Ref. M/62/19/PL

Planning Application for a 2-story
dwelling in Sundale Lane.

First Floor Plan

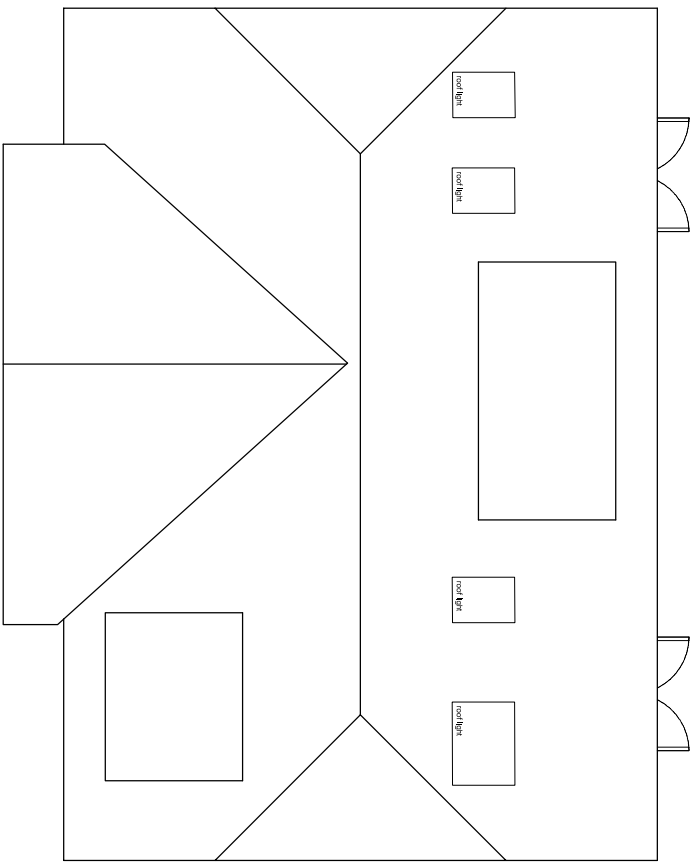
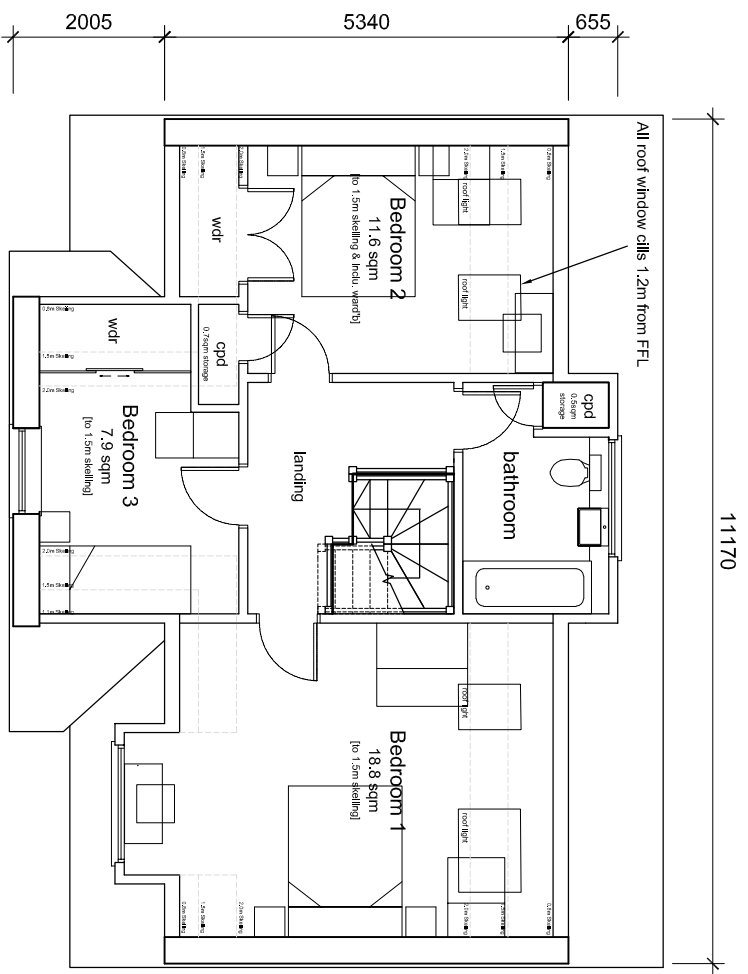
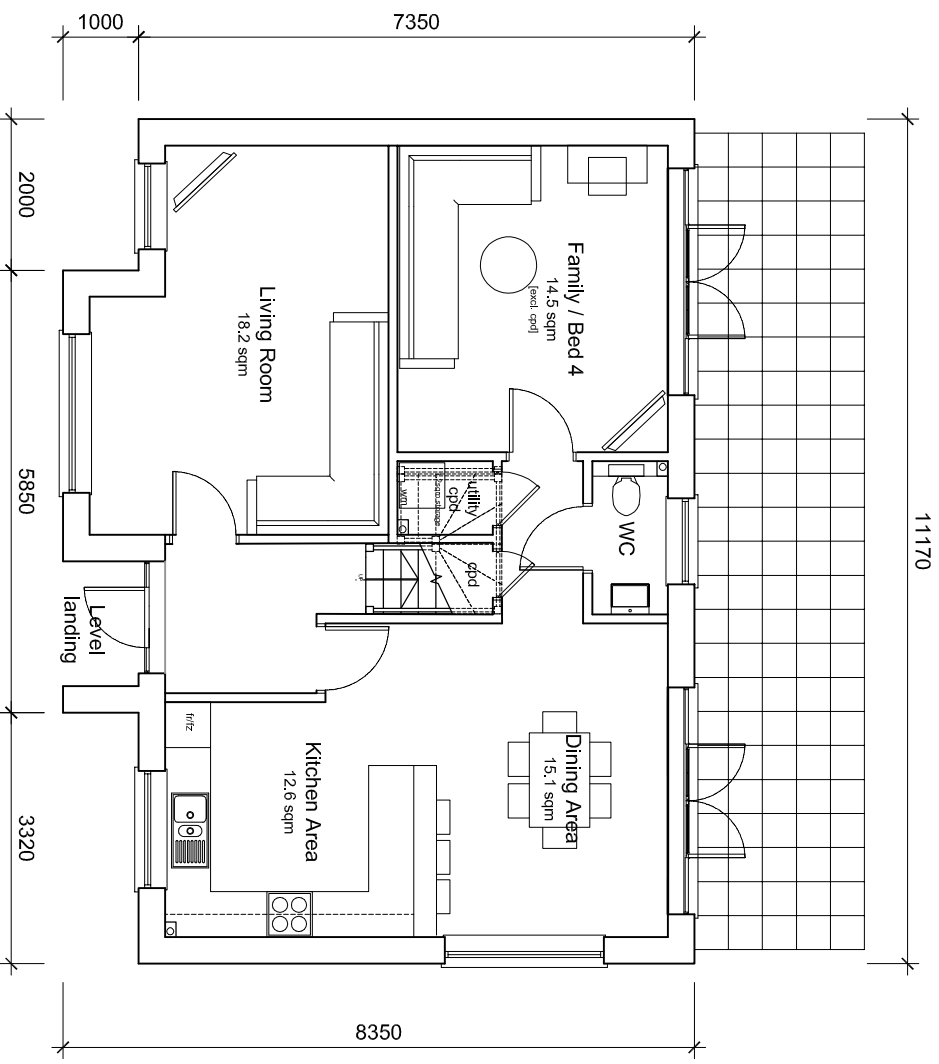
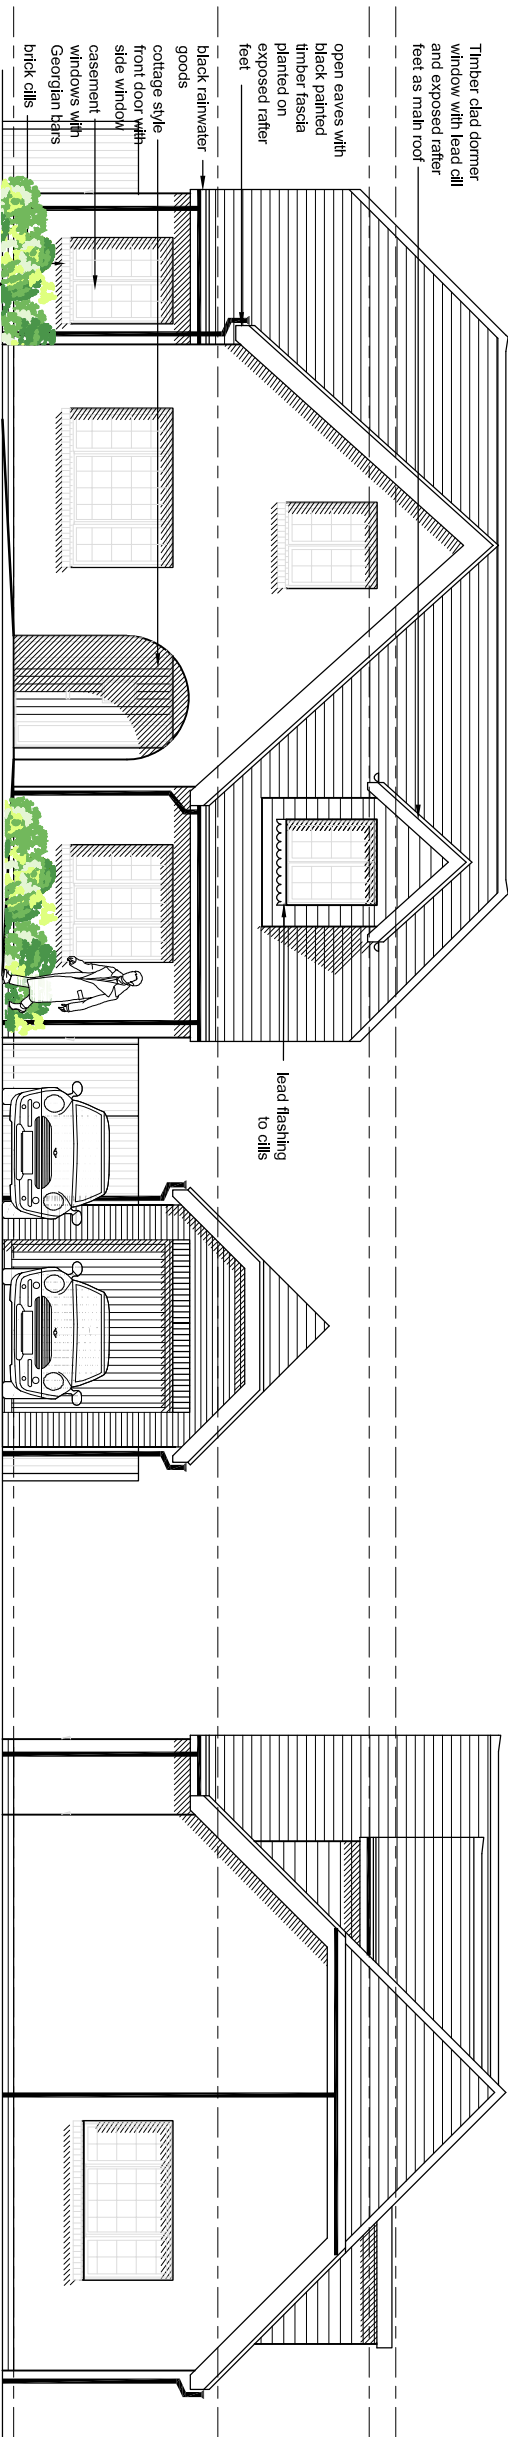
② The proposed property would, from the first floor, look directly into my garden

Front Elevation

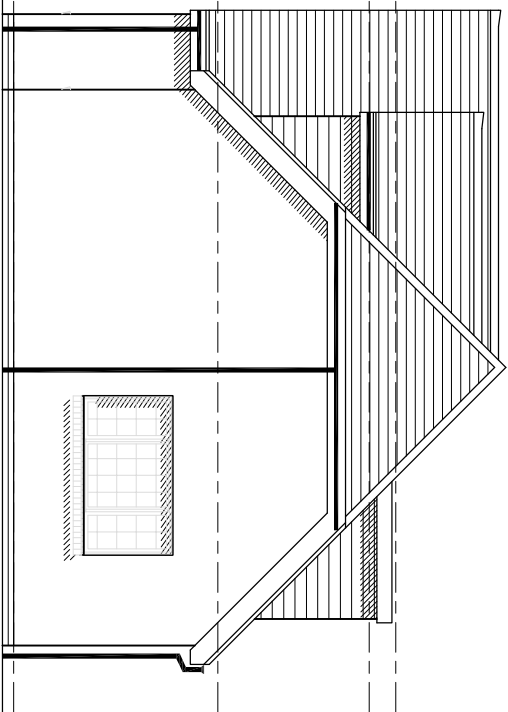
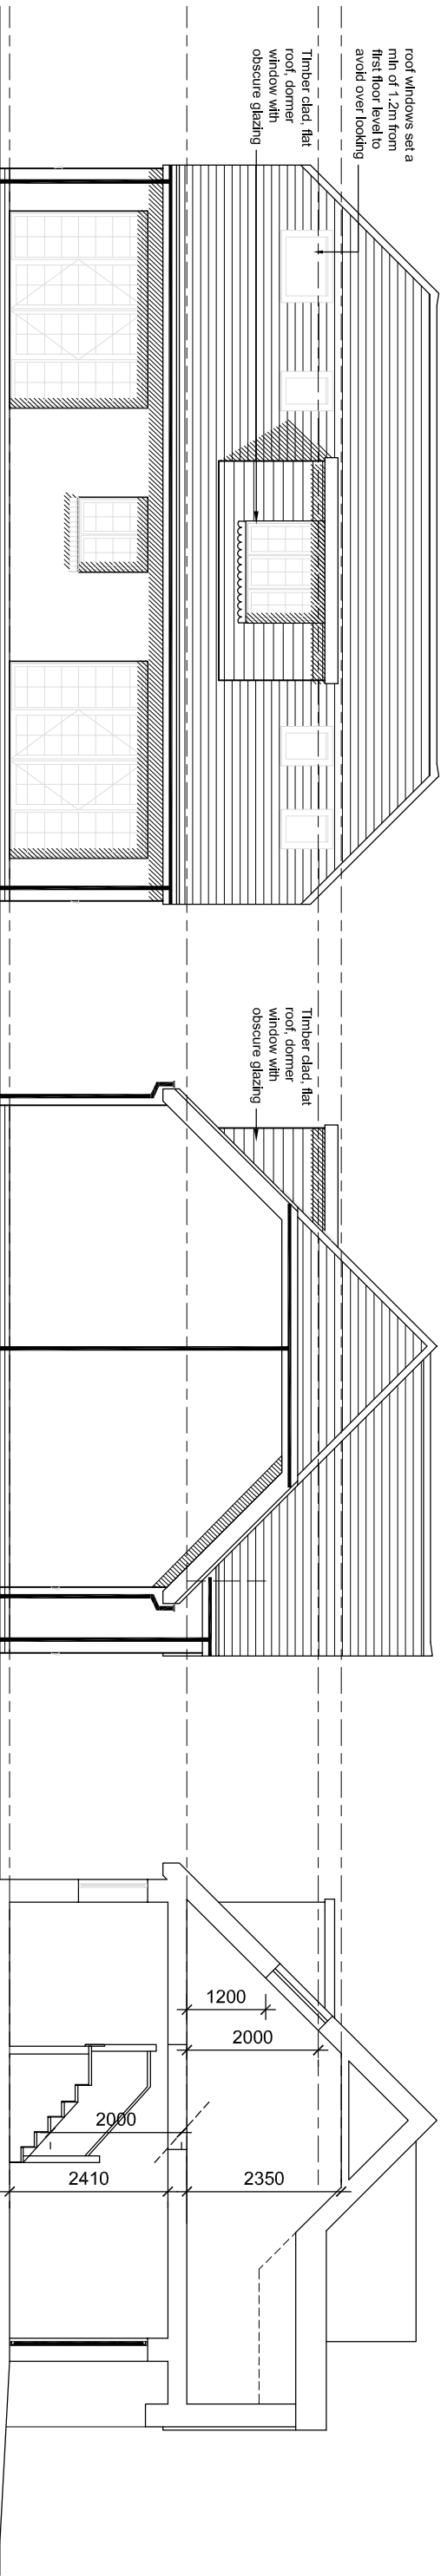
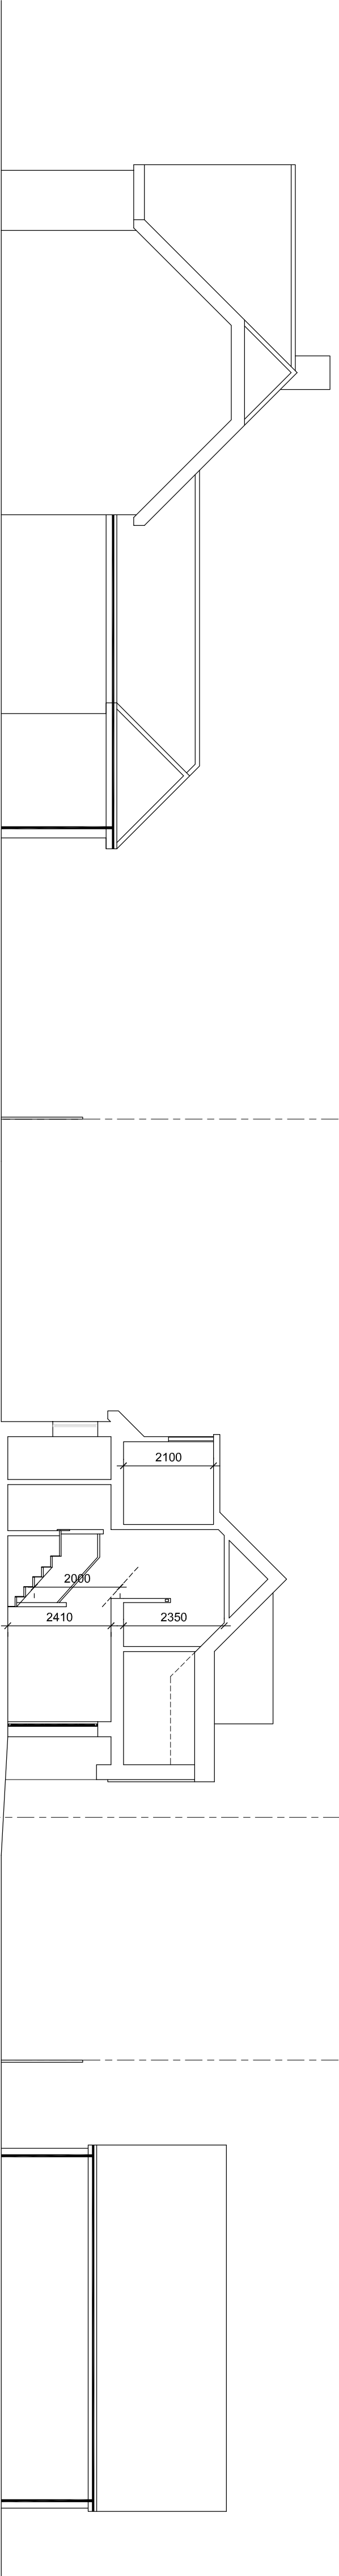
① Sundale Lane runs along the side of my property. The houses in Sundale Lane - at this end - and in Yapton Rd are all bungalows/chalet bungalows. The proposed property would, in my view, not fit in with this style.
